**Shoalhaven Cancer Care Centre- State Significant Development (SSD) 4952-2011
Response to exhibition submissions**

This letter responds to the agency and public submissions received during the exhibition of State Significant Development 4952-2011 for the Shoalhaven Cancer Care Centre, which occurred in December 2011. It also outlines a minor modification to the submitted plans as a result of on-going consultation with Shoalhaven Council.

Response to Submissions

2 STAGING PLAN
1:500

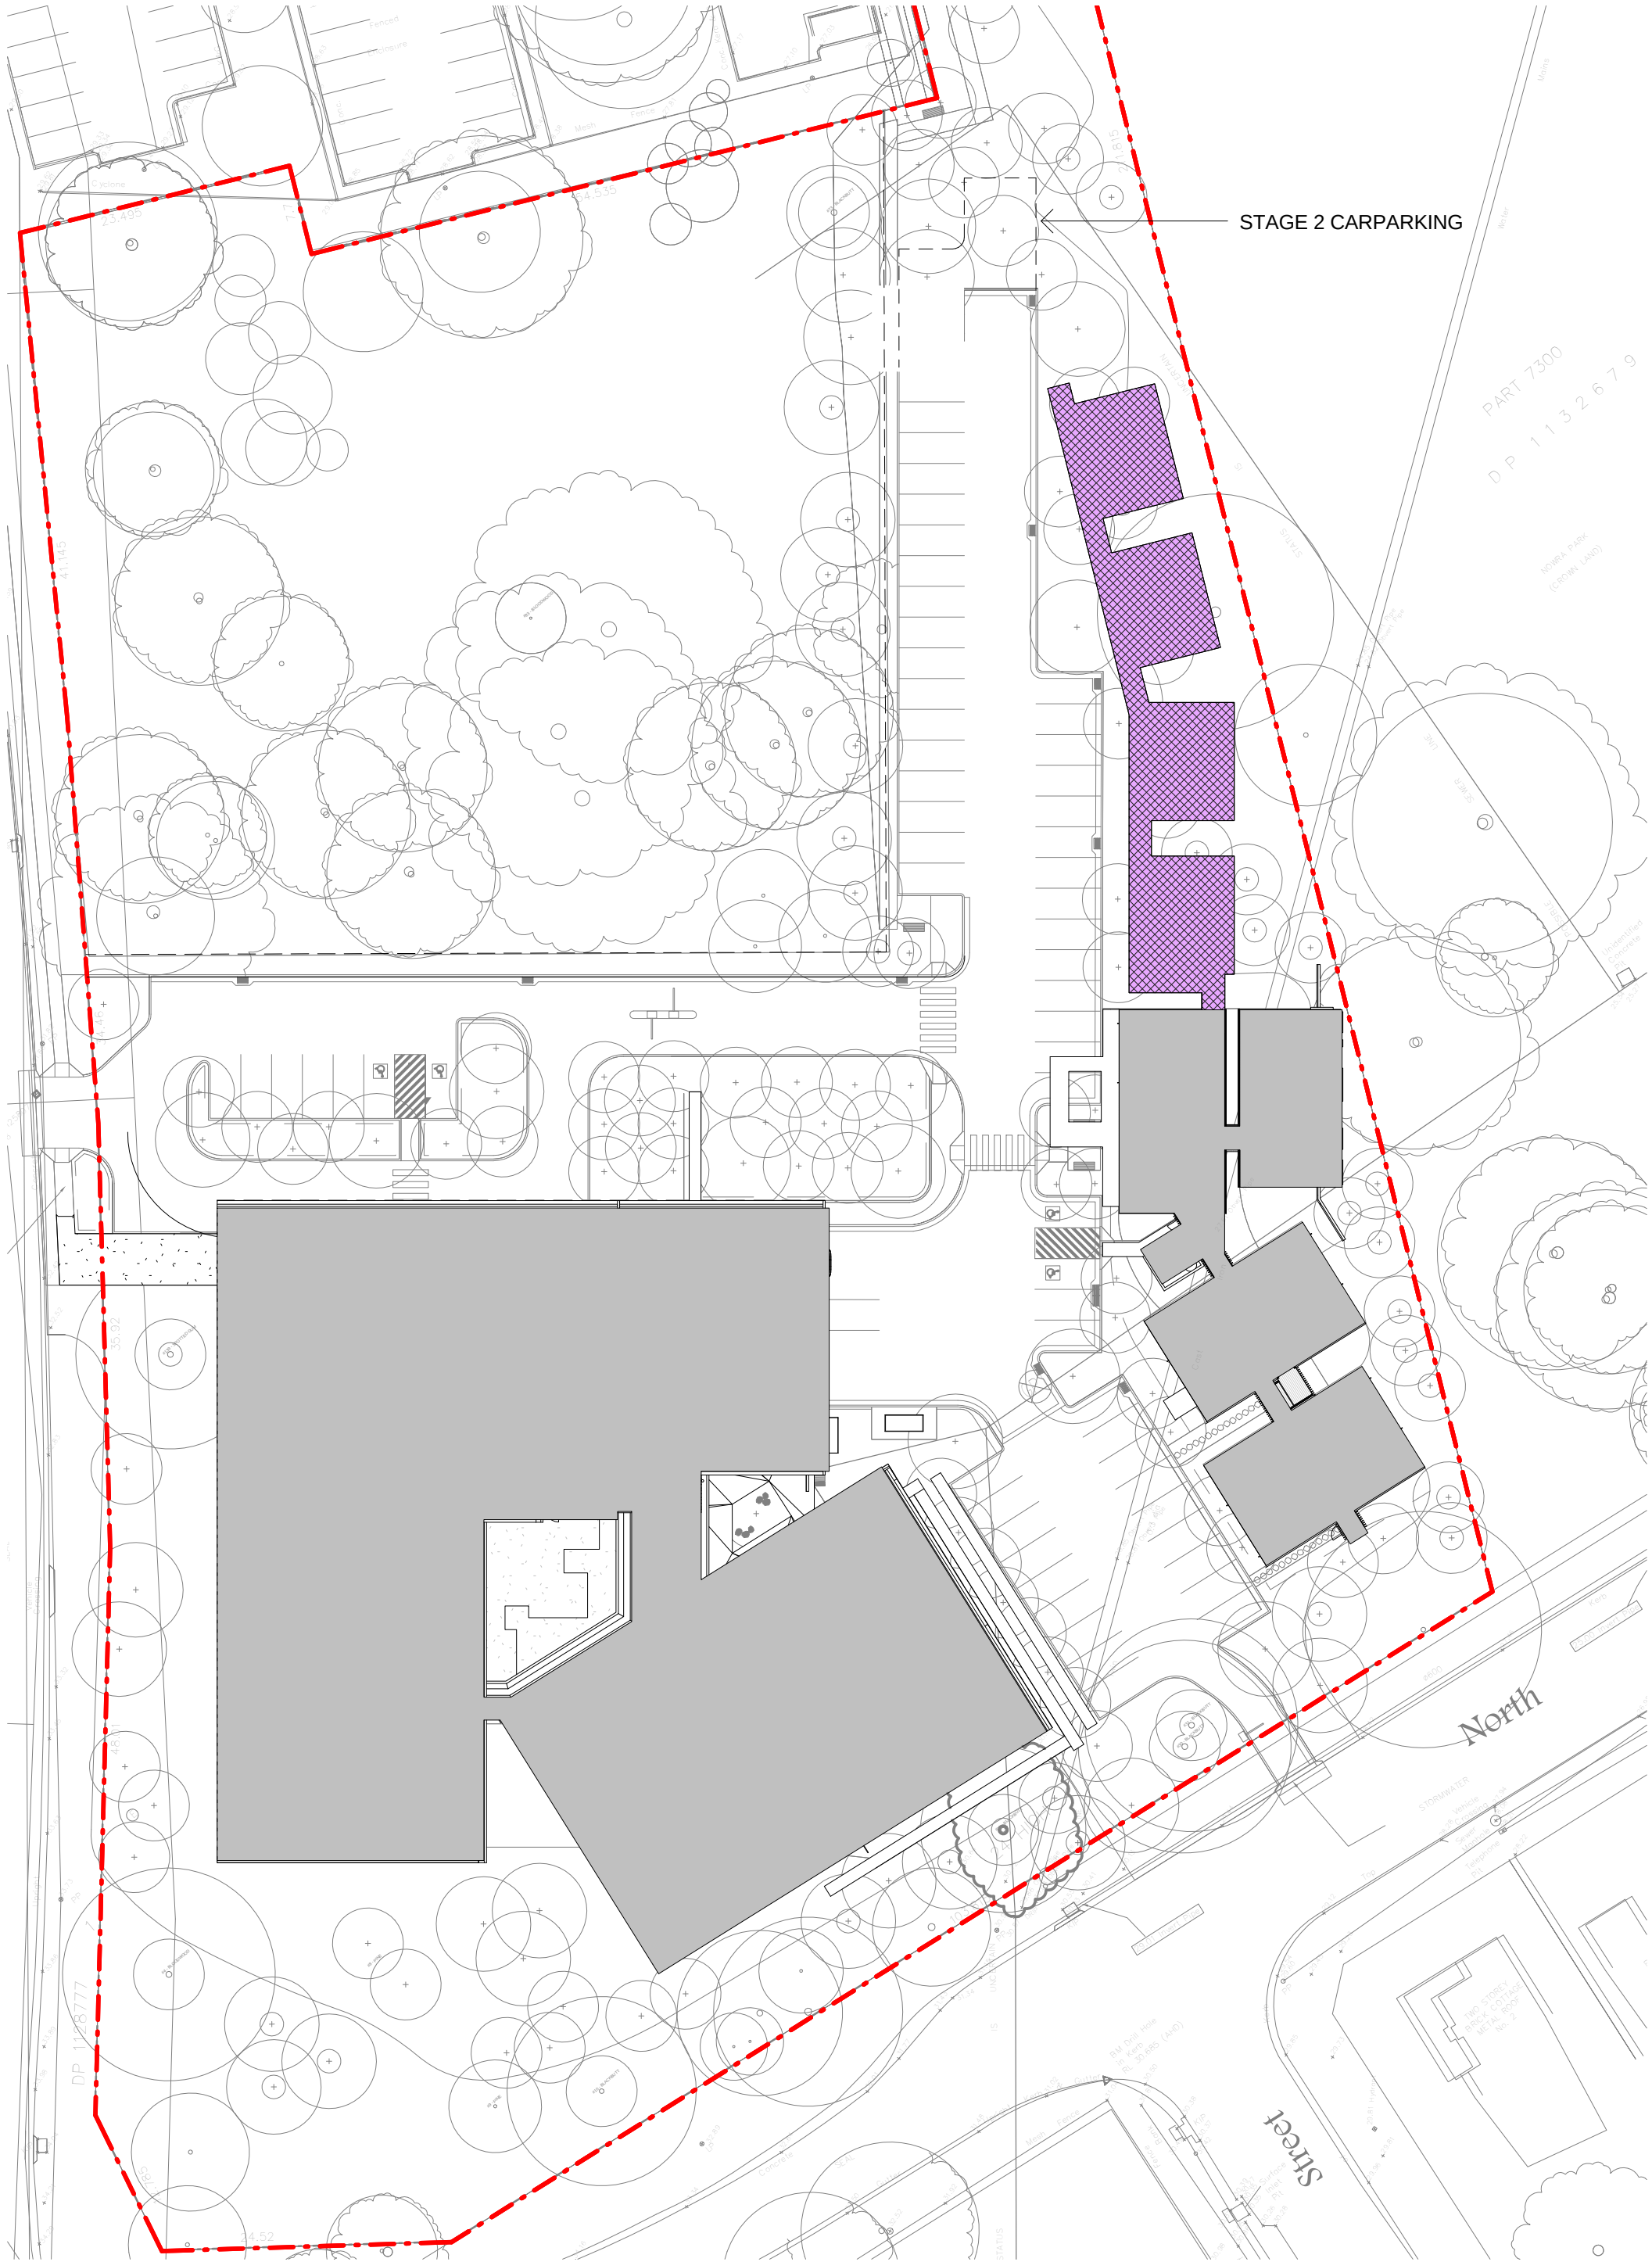
1.2 Stage 2 Parking Requests confirmation on 'stage 2 parking' as shown on proposed site plans.		Stage 2 car parking is an additional 4 spaces that will be constructed in conjunction with Stage 2 carers accommodation if Stage 2 goes ahead at a later date.
